Application No: Y/123/21/PL

Site Address: Land to the south of Ford Lane and East of North End Road Yapton BN18 0DS

Description of works: Variation of condition imposed under Y/82/20/RES relating to condition 1 - plans condition.

Thank you for your internet representation made on 10th September 2021 which has been recorded as an objection with the comments as follows:

ENCLOSURES PLAN

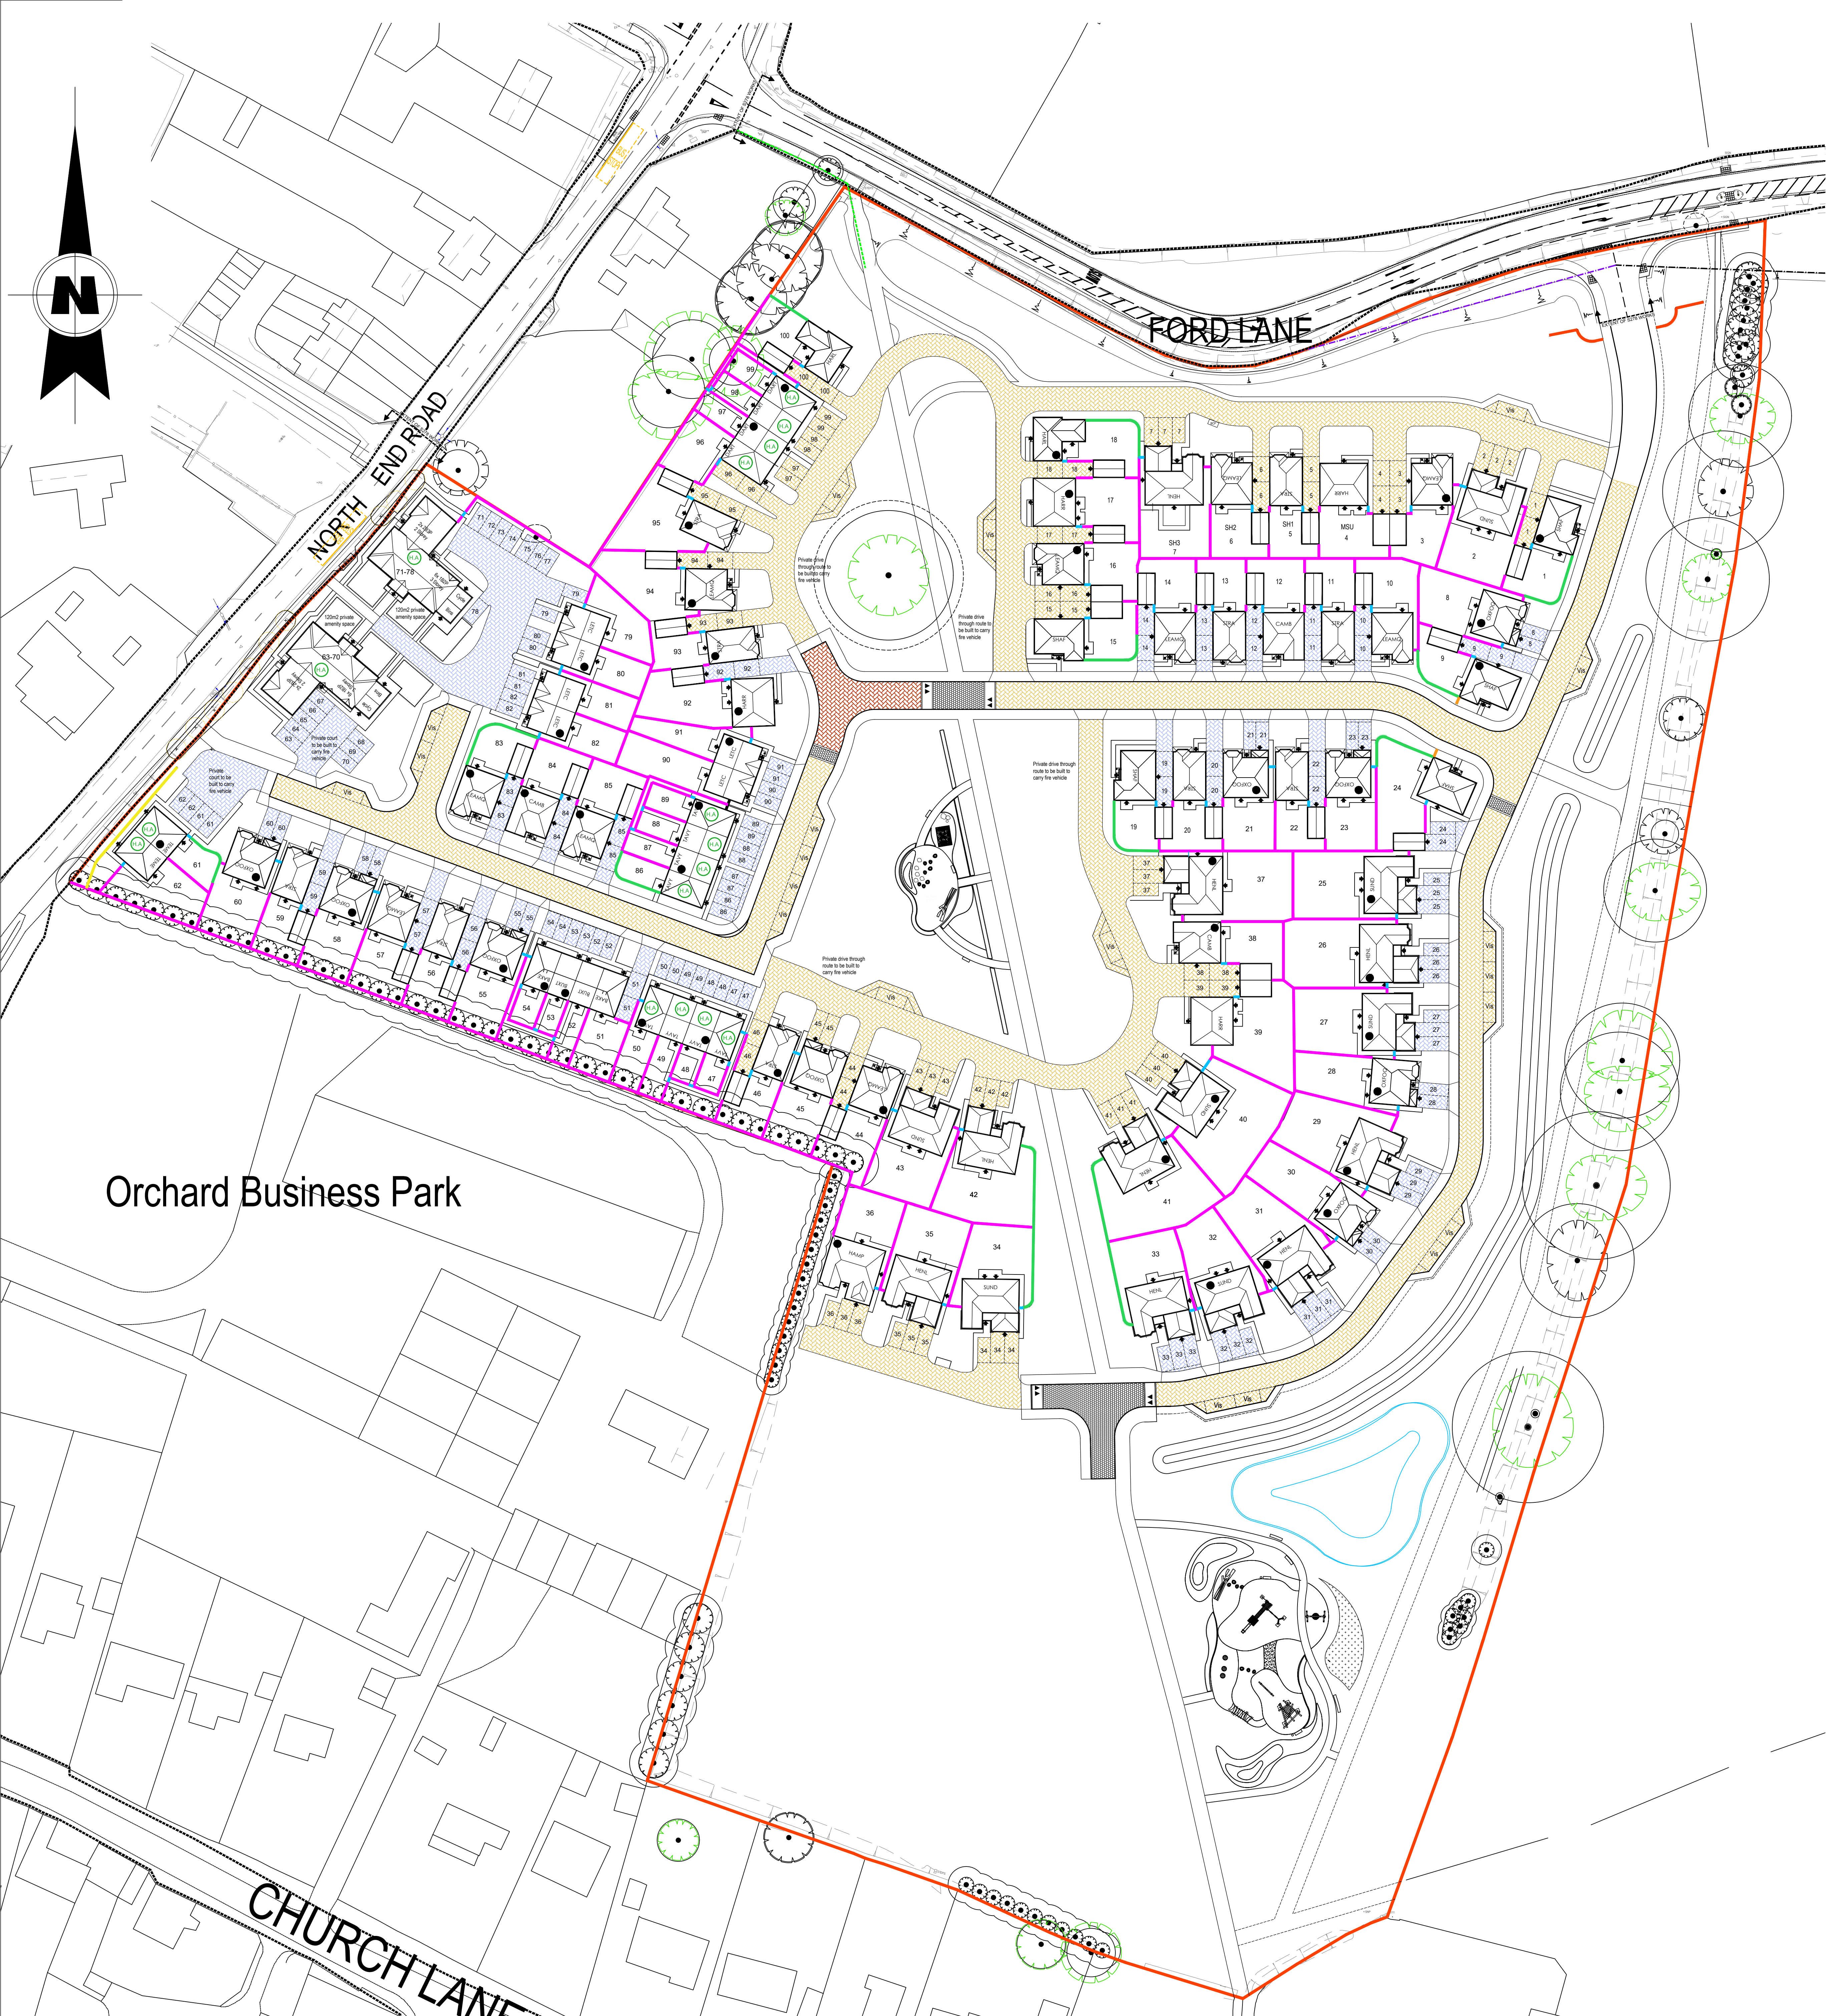
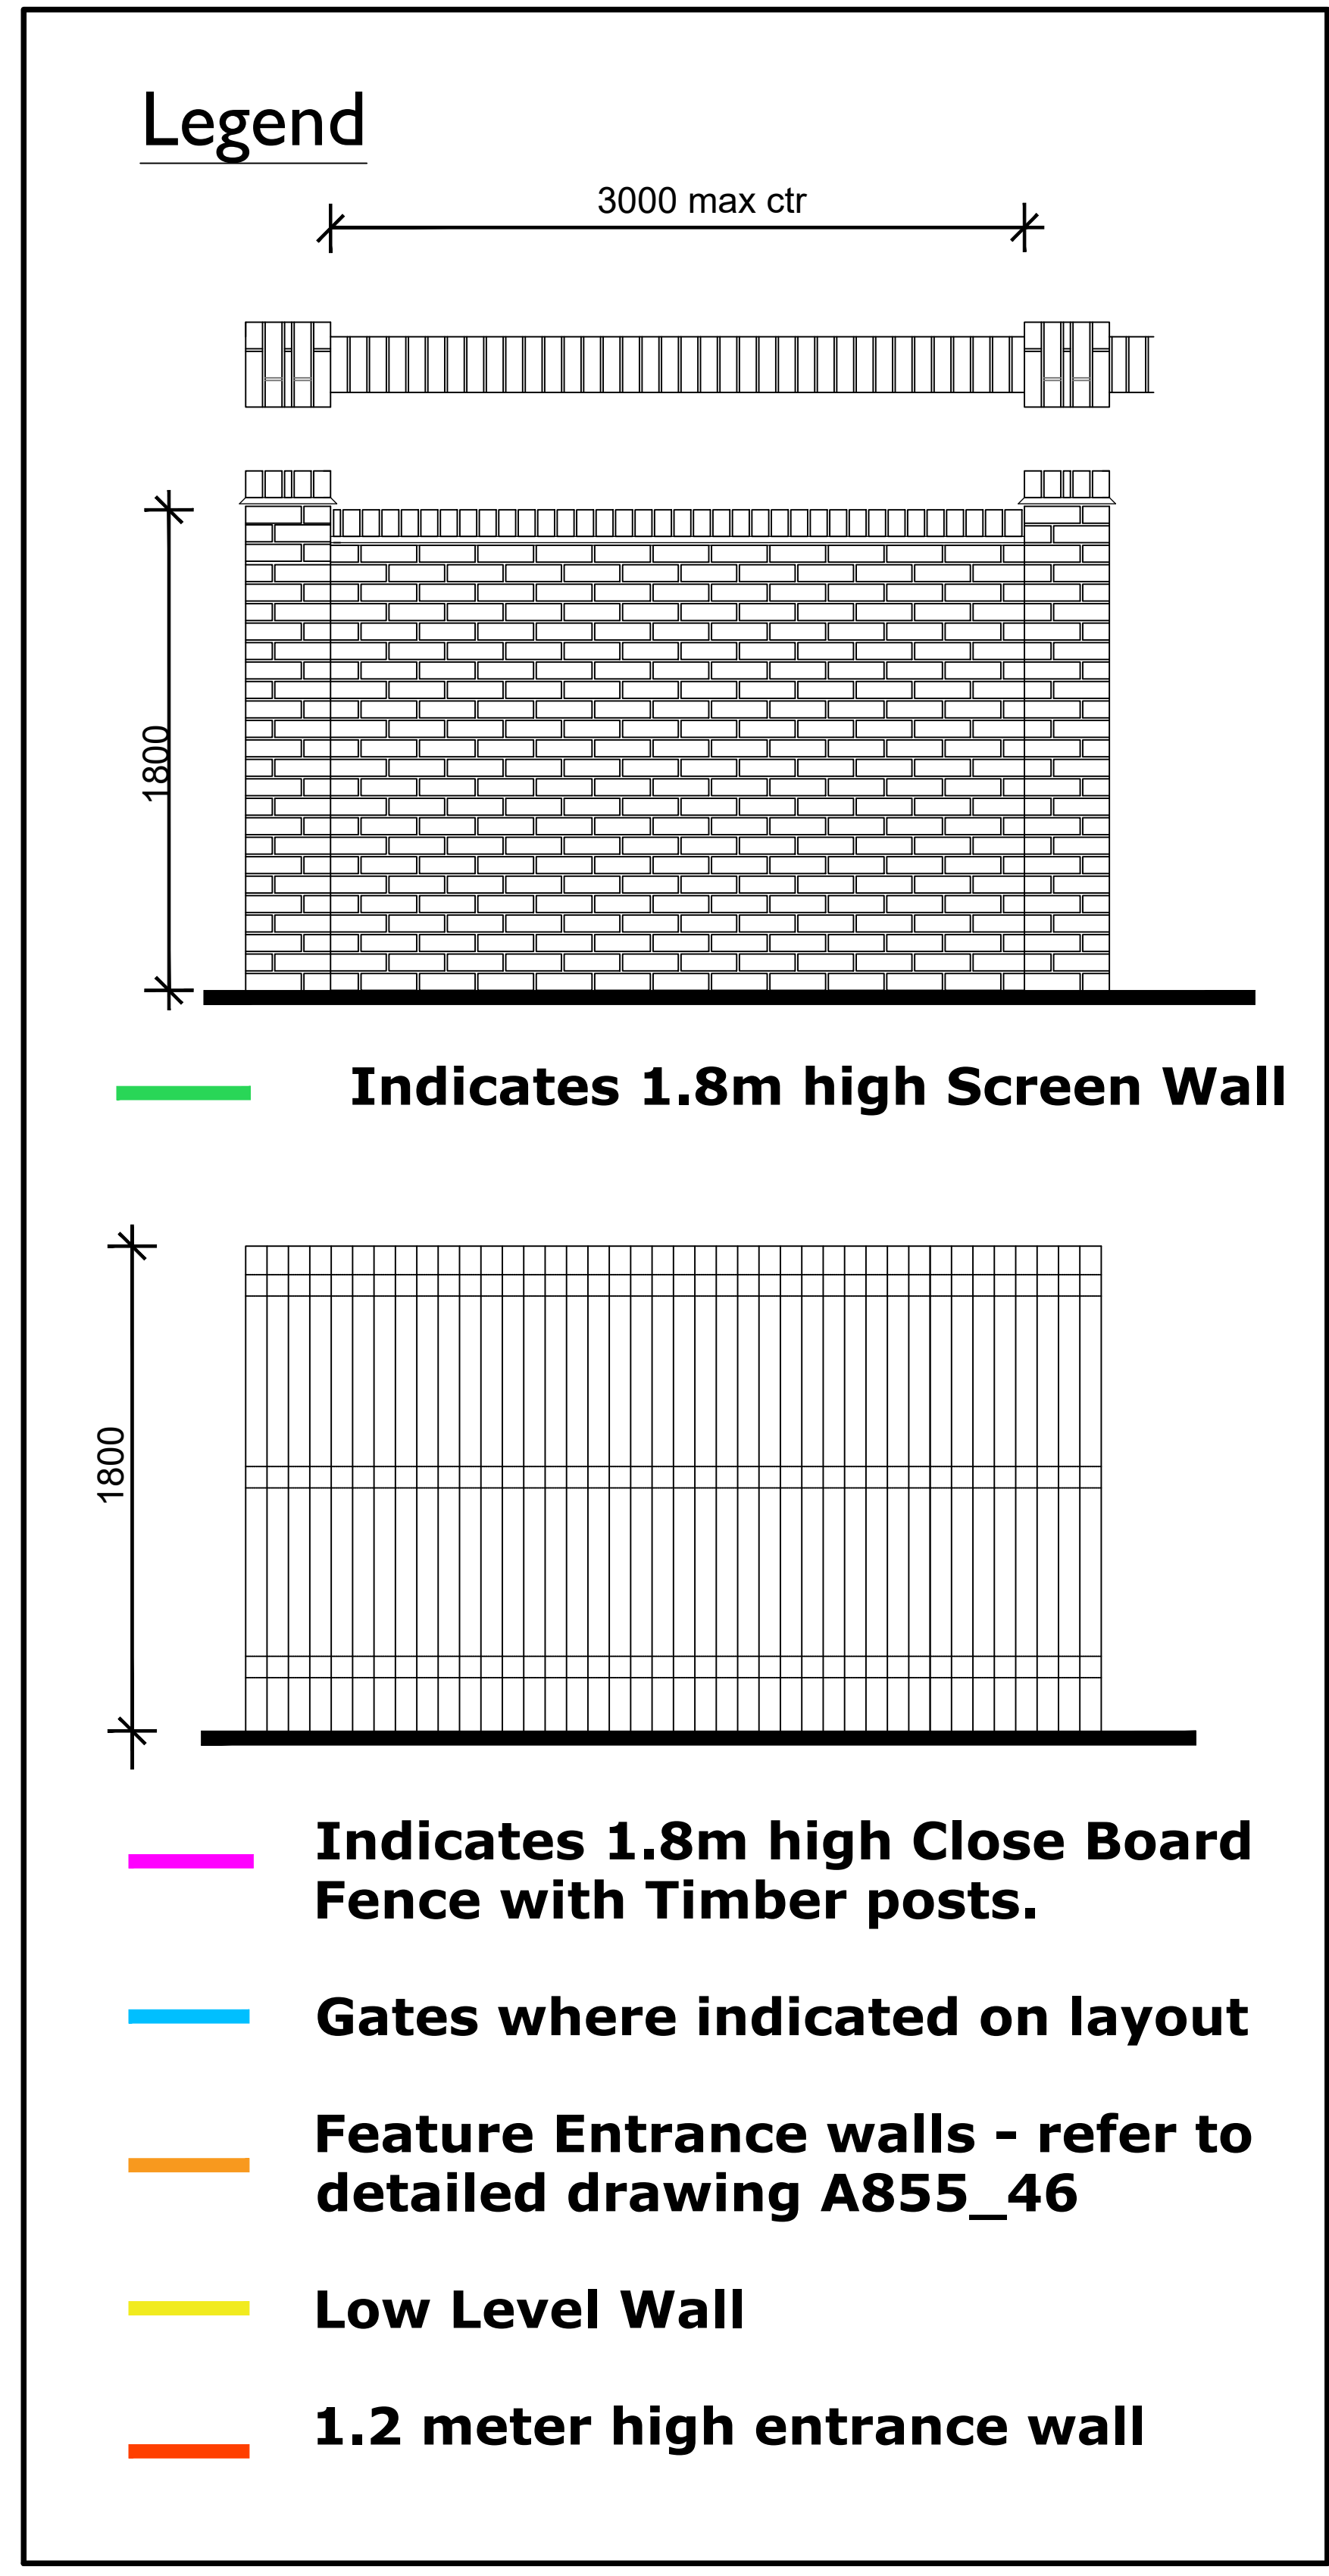
The enclosure plan relies on the existing trees and hedgerow along the South Western boundary between the public open space (below property 36) and my house, which is incorrectly shown as Orchard Business Park - my property is between the proposed development site and the business park.

There is no provision to prevent the movement of people and dogs from the public open space onto my private property through the gaps in between the trees and hedgerow.

The 1.8m wooden fence that is proposed along the western edge of the garden of plot 36 must be extended down the whole length of the western edge of the public open space.
